LETTER OF INTENT FOR: SADDLEHORN RANCH 824 ACRE CURTIS ROAD SUBDIVISION

Final Plat Filing 1

Amended July 08, 2019

LOISF_v2redlines.pdf Markup Summary

DEVIATION REQUEST EXHIBIT

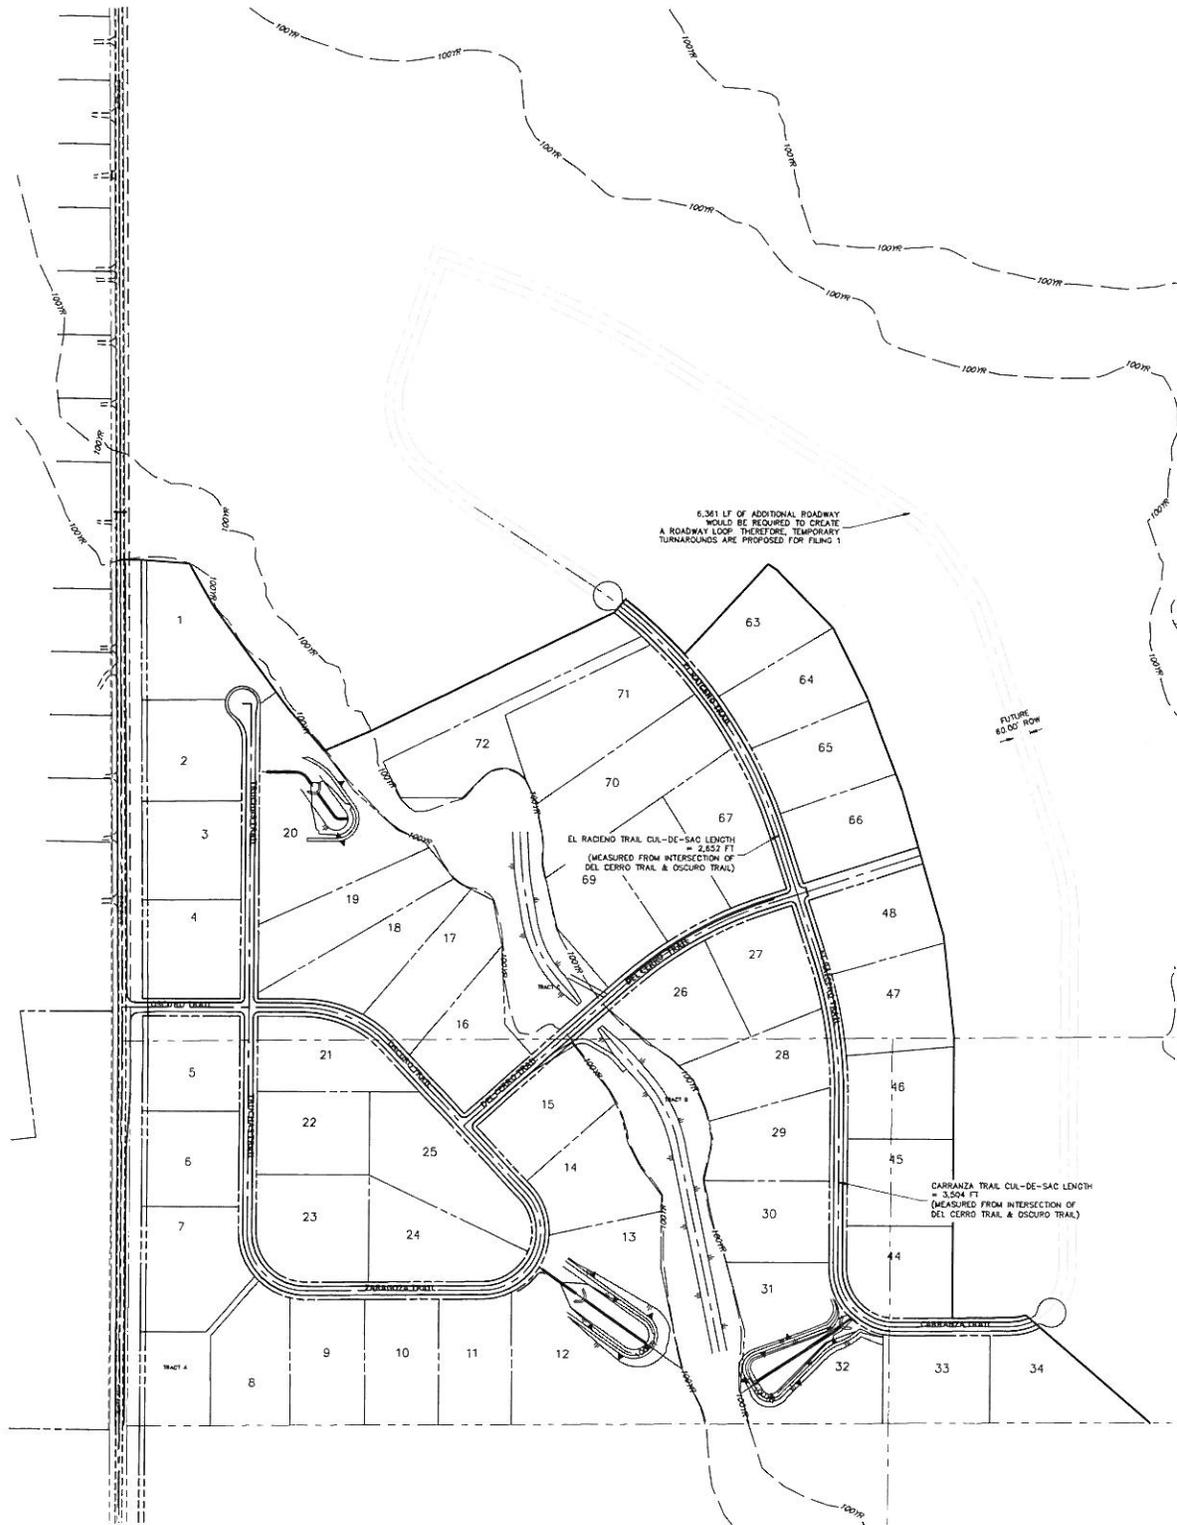
2.A waiver of LDC 8.4.4(D) is required for more than 25 lots on a dead-end road, and a deviation request (ECM 2.3.8.A) is required for a cul-de-sac length in excess of 1,600 feet. Mention all waivers and deviations
